From: Michael Eastham
Sent: 31 January 2019 12:50
To: Planning.Responses
Cc: Karen Garner
Subject: FW: BN/59/18/DOC - Redrows - Lake Lane, Barnham (phase 2) - Former Pollards Nursery site.

From: Laura Gibbons
Sent: 31 January 2019 12:36
To: 
Cc: 
Subject: RE: BN/59/18/DOC - Redrows - Lake Lane, Barnham (phase 2) - Former Pollards Nursery site.

Ditch Filling Detail

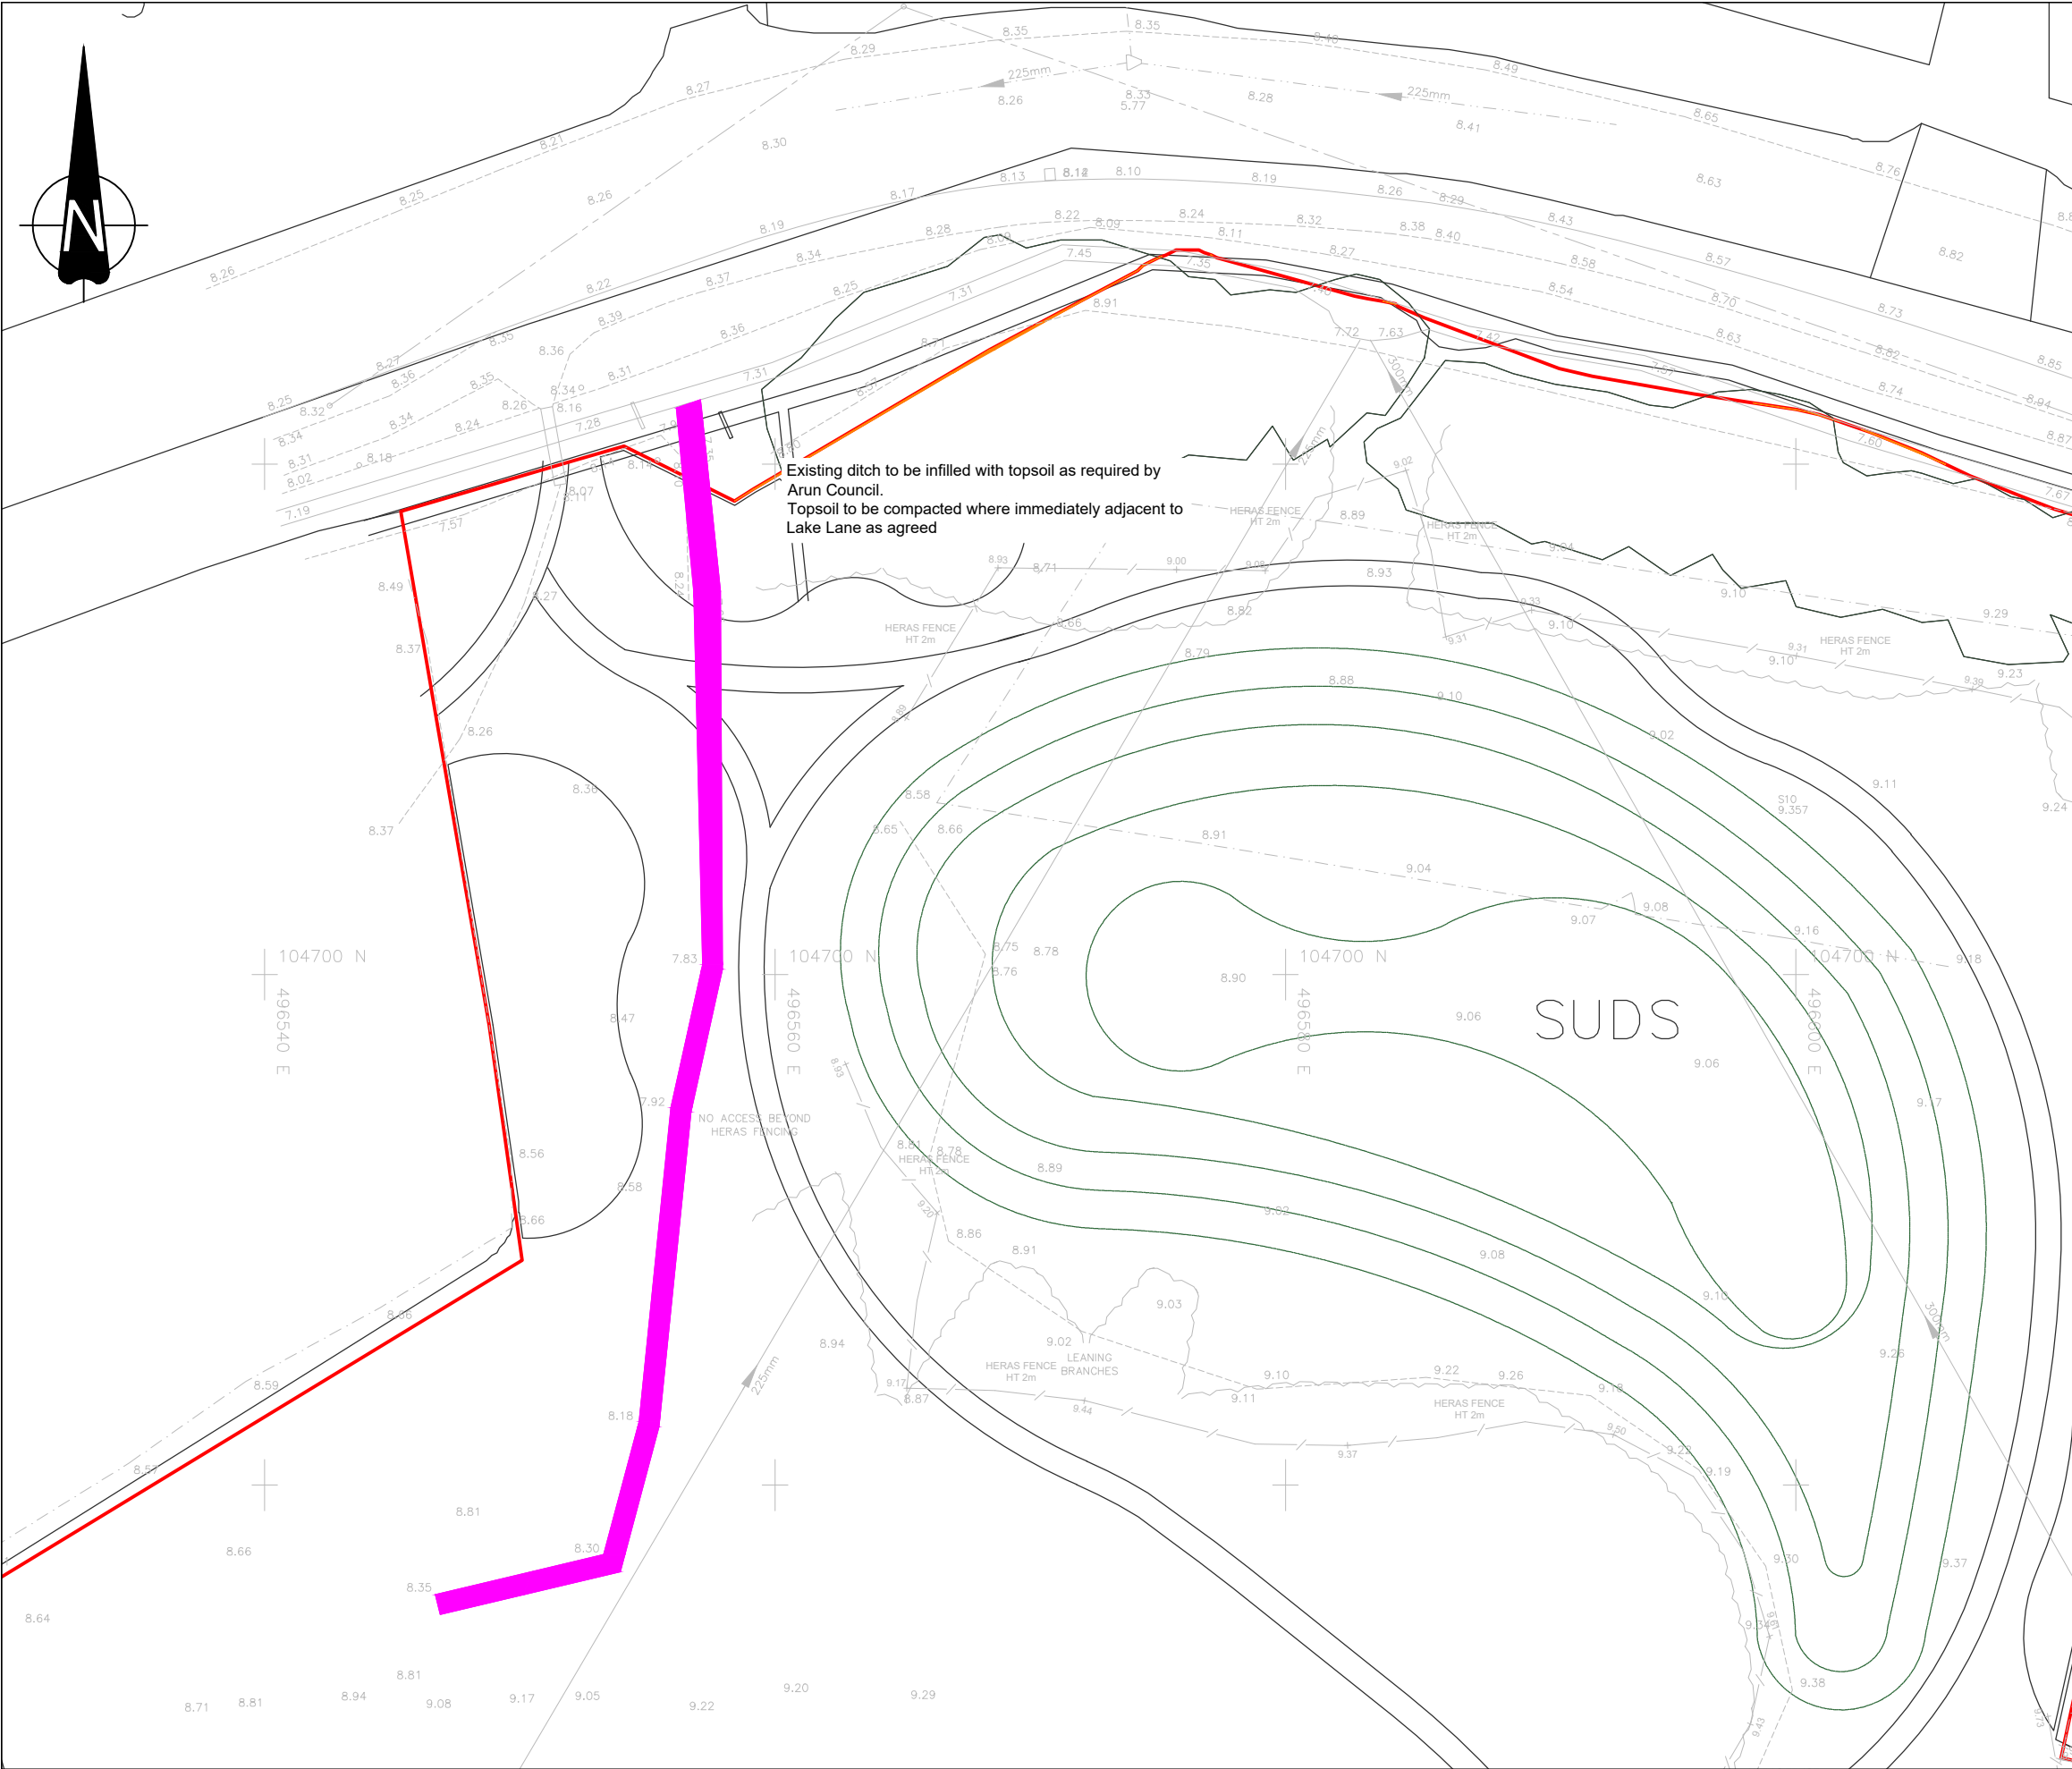
1. It is agreed that the ditch to be abandoned is within Redrow owned land.
2. The entire ditch is to be filled with a semi-permeable soil. We will await your suggestions in this respect. Gravels/hardcore, etc, should not be used, but something more likely to blend into the environment.

3. All non-organic material to be removed from the ditch prior to filling.
4. The existing 150mm diameter pipe under the abandoned field crossing should be left in place, rather than removed, due to the potential to cause damage to tree roots.

5. Please provide suitable drawings detailing the ditch filling.
6. I suggest that an arborist is consulted to ensure that no root damage occurs during the infilling ie. construction vehicle loading.
